Summary of Response to Pre-Application Feedback

The application follows Pre-Application submission (S/22/0014/PREAPP), and this Design & Access Statement looks to address feedback received by Case Officer Edward Evans, 21/07/22.

**01** Proposed: Drive Detail 01  
1:100 @ A1

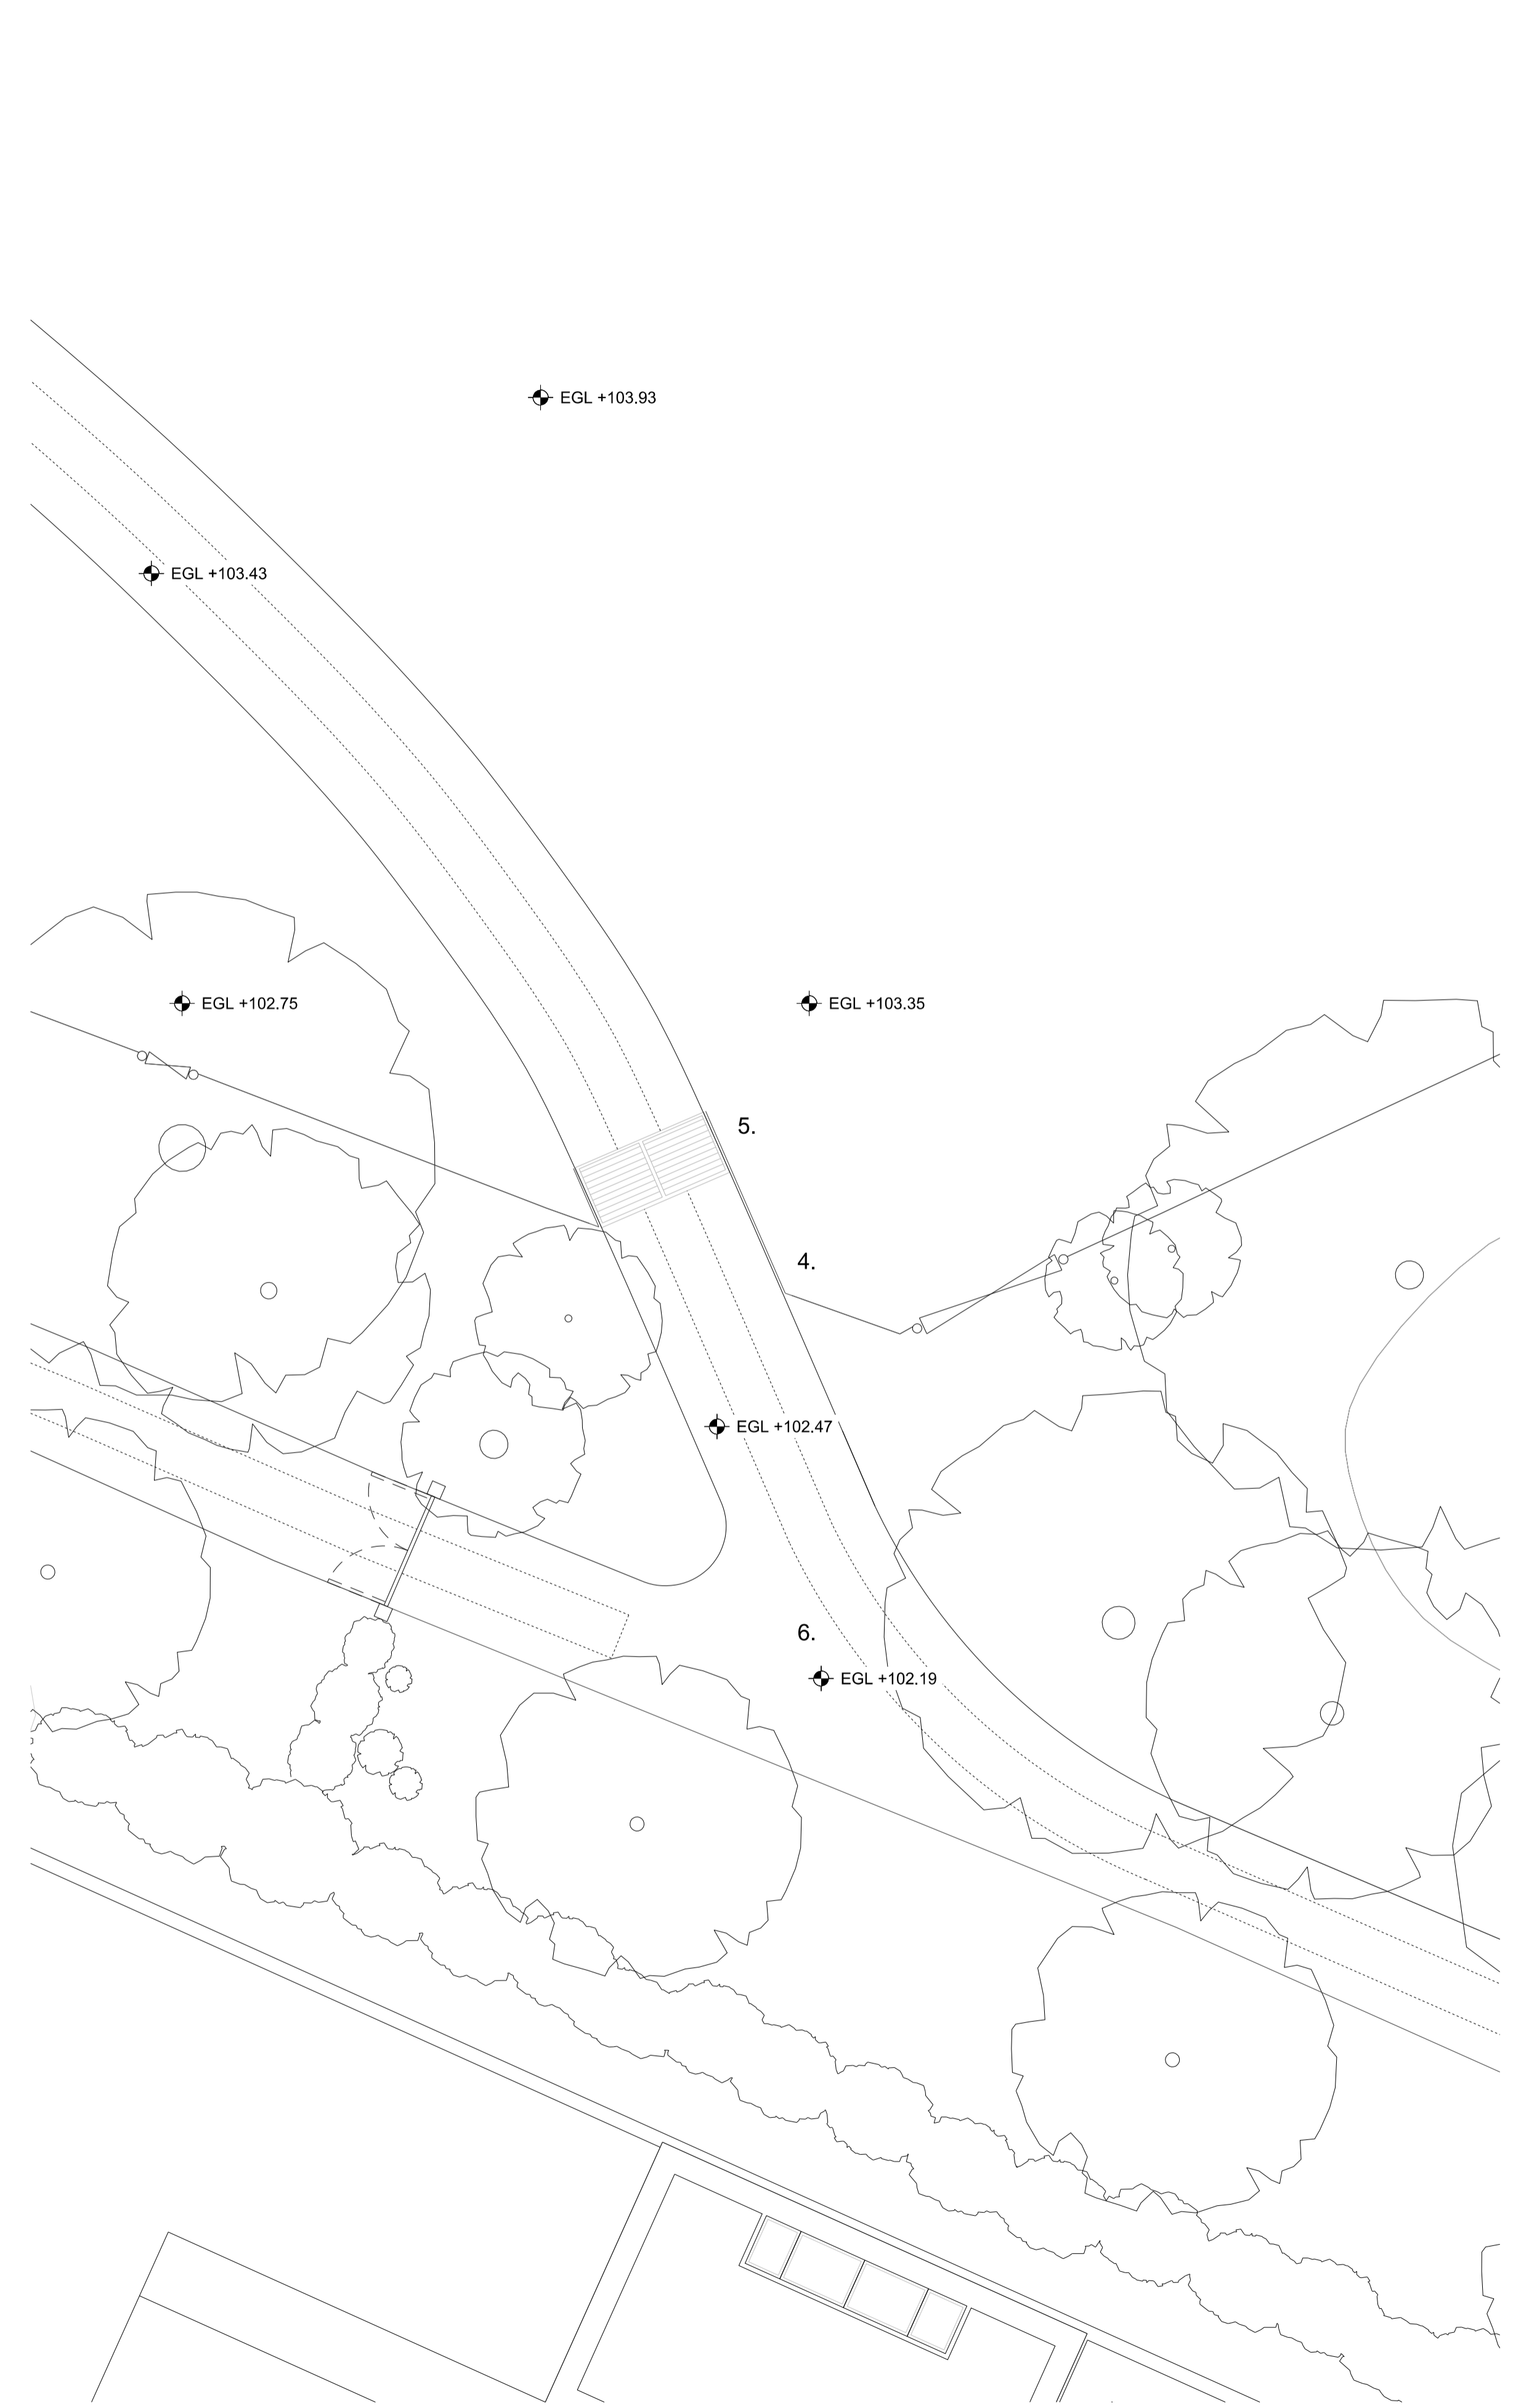
The re-aligned driveway would improve access to the house, removing service traffic from the front and side of the house. This may be acceptable, however further detailed information is required. Depending on the exact alignment of the route, some trees may be impacted and there are associated concerns about the impact on the landscape. During the site visit, an area was identified where there would be minimal impact on trees. Further investigations would need to be carried out to investigate the impact on tree root protection areas. The alignment of the proposed new route would be on land which slopes up from the existing road. Further information would be required about levels and if the road would need to be cut into the site.

Developed information forms part of this application and should alleviate Officer concern. The proposal for a new driveway route has been amended following the Pre-Application. The proposed ingress point has been revised to avoid unnecessary tree removal, this point was identified on site 29.06.22 and is supported by an arboriculturist report. The arboriculturist report has been submitted as part of this application.

Title
**Proposed Pool House
North East Elevation**

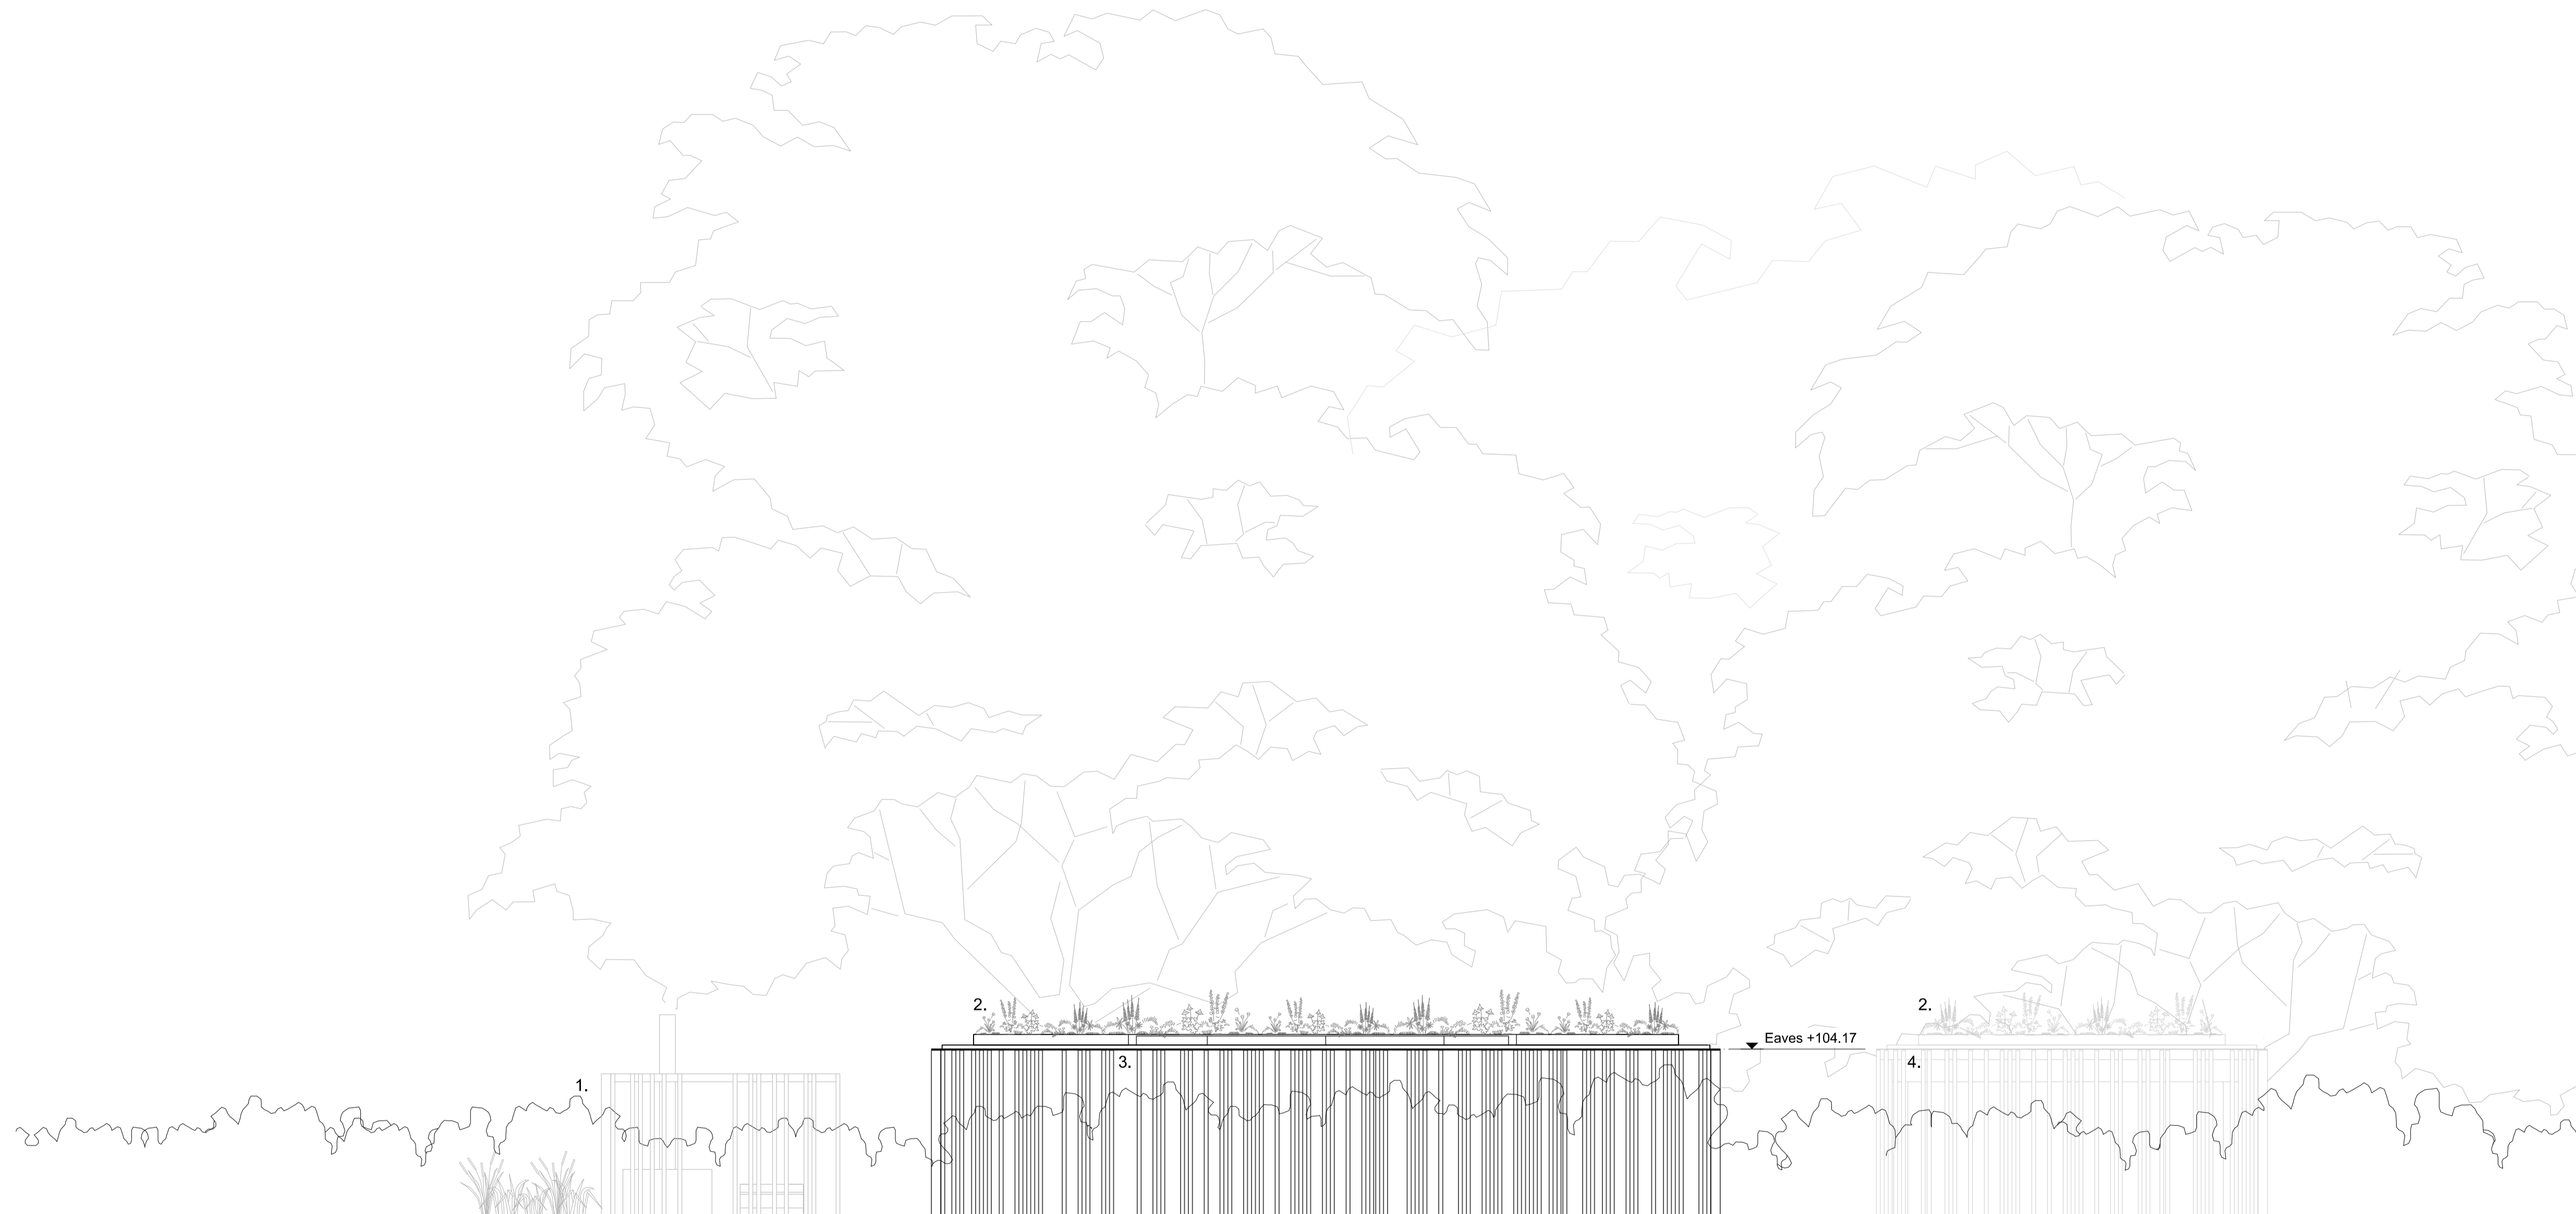
The proposed pool house structures have been designed as a contemporary addition. The buildings would be prominent on entering the site. The pool house would be 3.2m high but would take advantage in the natural fall in the landscape from the driveway, making it 2.2m high adjacent to the drive. A flint wall is proposed reusing flint from localised areas of demolition elsewhere, however it is not clear where this flint would come from. A new hedge is also proposed to help screen the new building which would be clad in hit and miss timber with a green roof. The yoga studio is separate from the main building but has a similar design.

Above the outdoor dining space and to the south of the pool house, there is a substantial timber frame pergola. This would substantially add to the overall mass of the building and this part of the proposal is unacceptable and should be removed or redesigned.

Following Pre-App feedback, the design has been revised to reduce the height by 200mm, and to visually break up the overall length by separating the external dining area from main poolhouse mass. The design has also been amended to open up the yoga studio to create a pagoda style structure that is open to the elements with reduced cladding. Visually, a loosening of the proposed vertical cladding has been proposed to reference the natural reed pool whilst improving permeability of the external areas.
